Planning Application Ref: Y/18/20/PL

Location: Land east of North End Road & West of Church Lane Nursery, Yapton

Description of works: 6no. residential dwellings & associated infrastructure. This application is a Departure from the Development Plan

Mark Warwick
Tree Officer / Parks and Greenspace Team

SGN 1 Monitoring tree protection

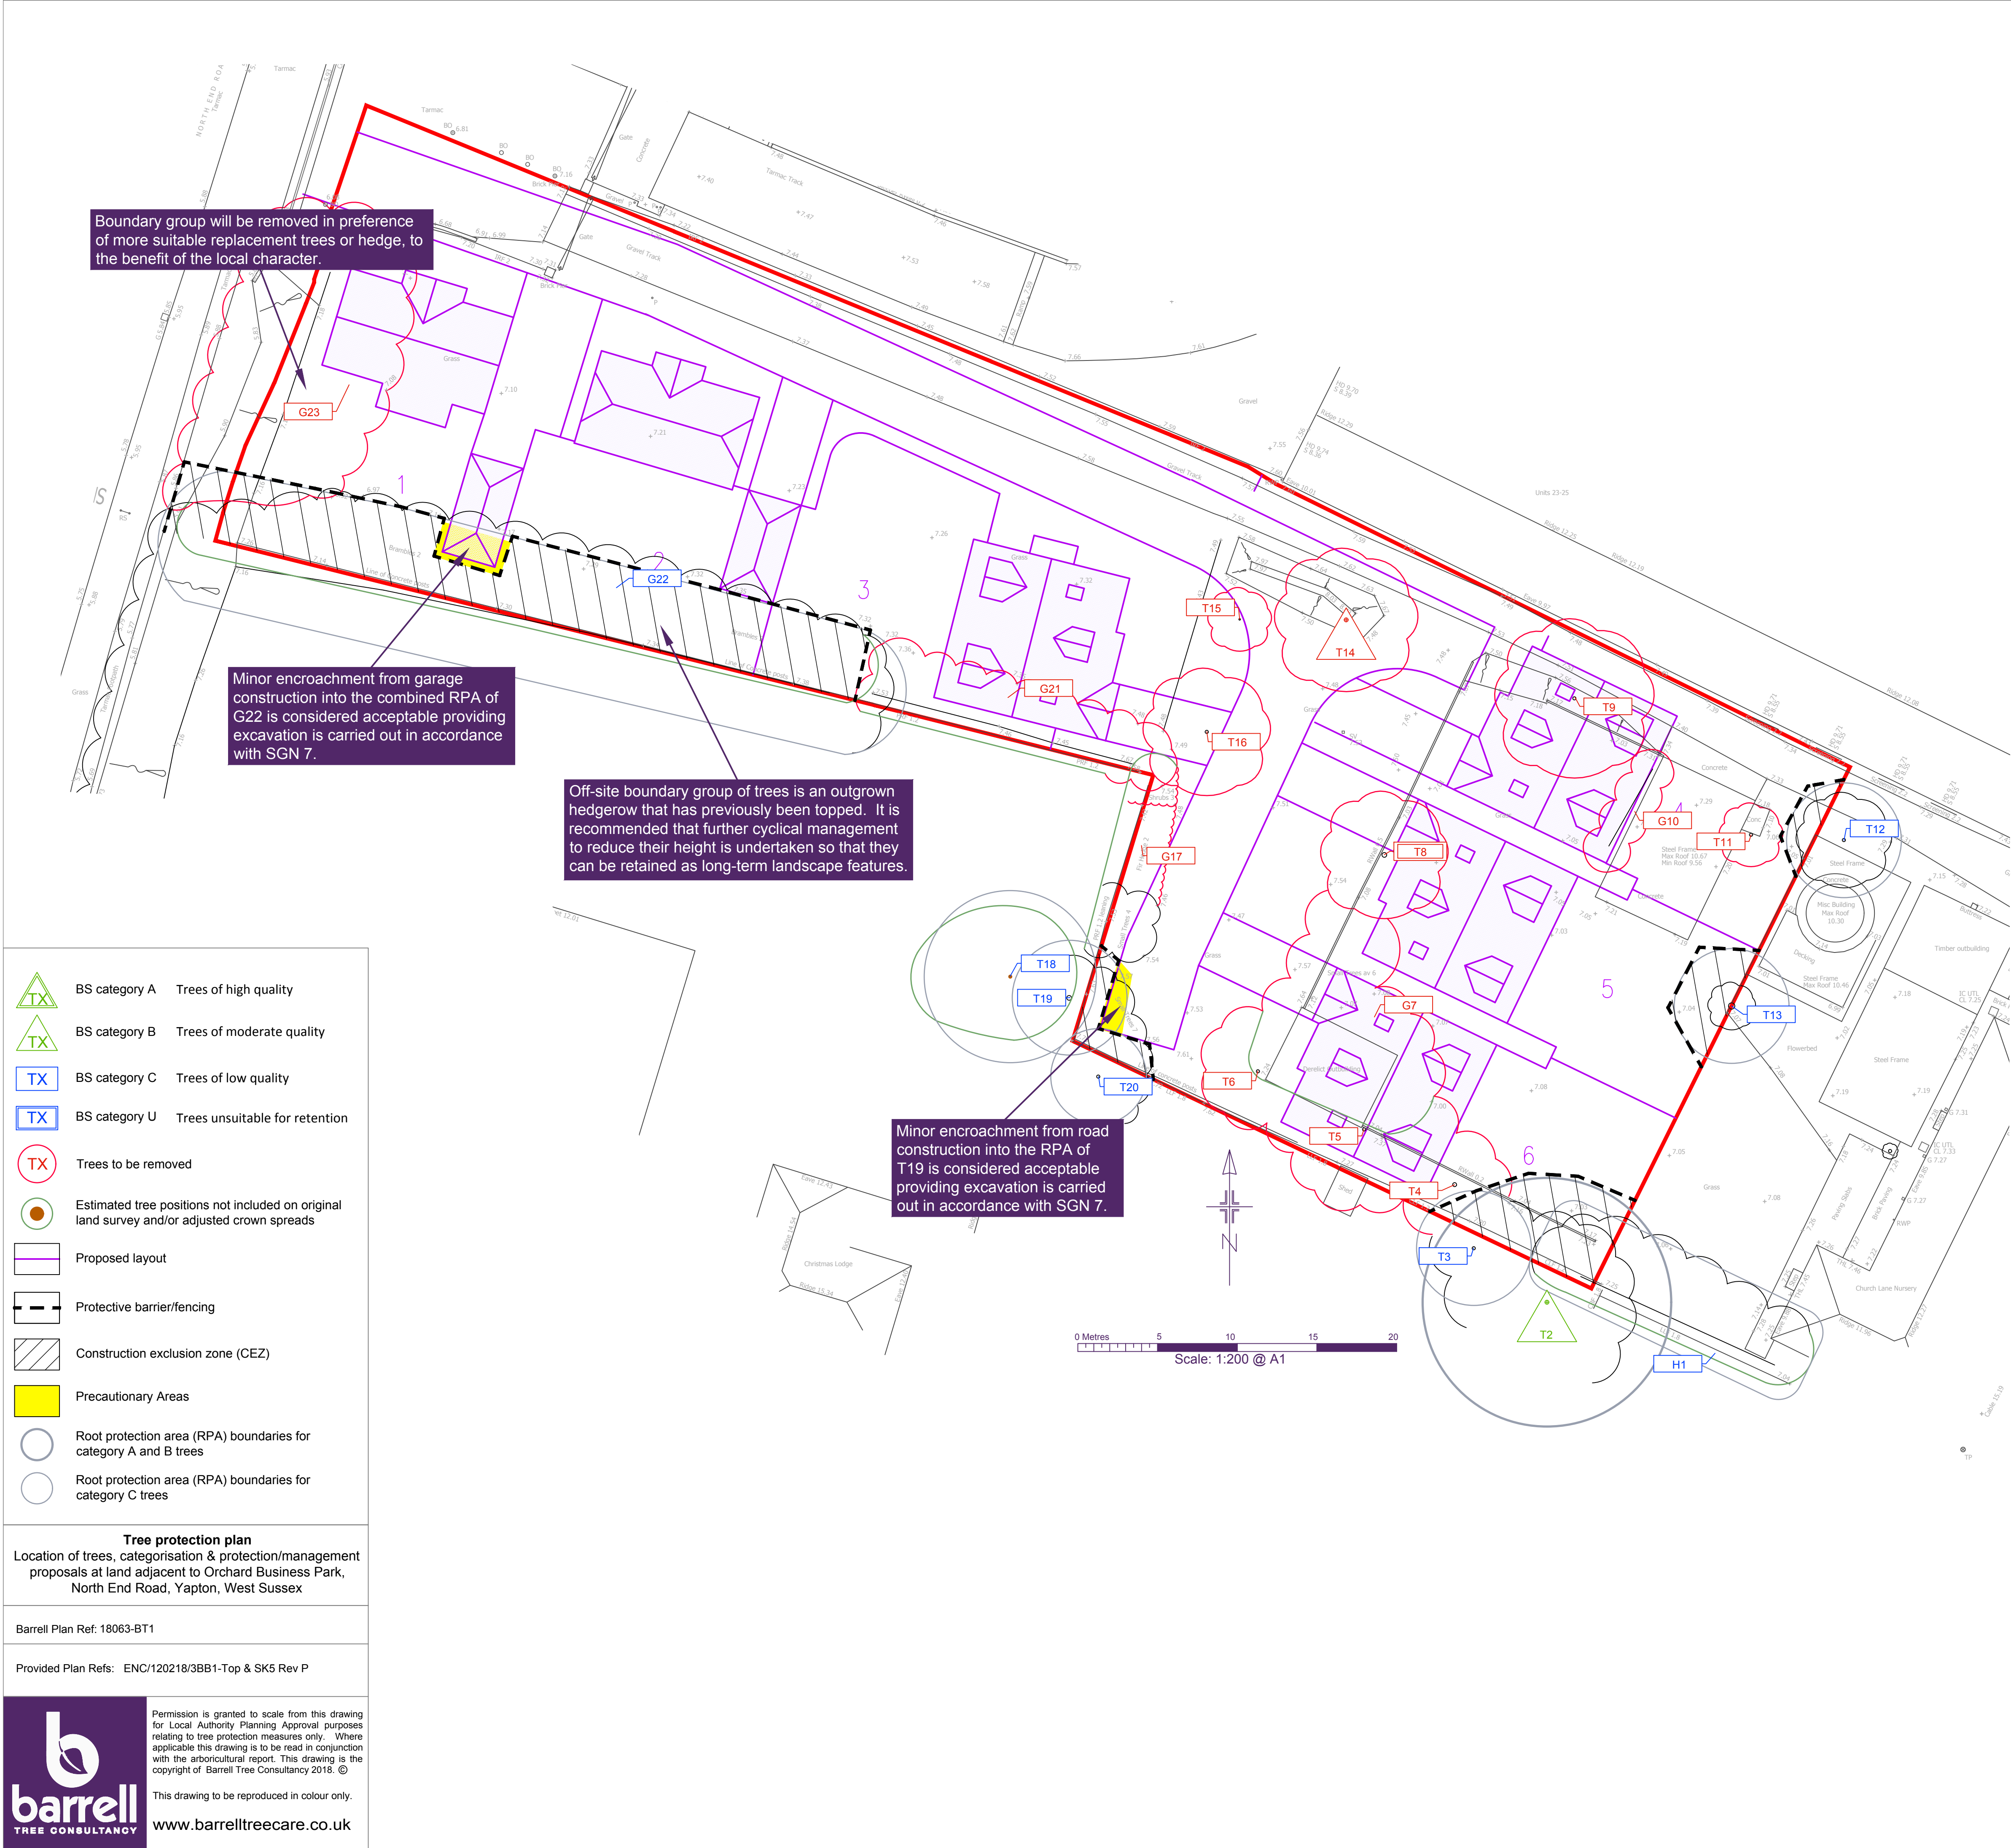
- As it stands, I am unable to lend this scheme my support and so register an OBJECTION. I see no obvious reason to sustain an objection on arboricultural grounds and so recommend the scheme for **APPROVAL** subject to the following conditions being applied:
 1. Before the site is occupied or any machinery is introduced to the site or demolition work or construction work or alterations to existing ground levels takes place a **PRE-COMMENCEMENT Site Meeting** is to take place between the Planning Authority's Tree Officer and the Arboricultural Expert representing the site owner(s) or other competent person – at this meeting all protective fencing will be inspected to verify it is 'Fit for Purpose' as required under British Standard 5837:2012 and have been erected and positioned exactly as shown on the **Tree Protection Plan, ref. 18063-BT1**.
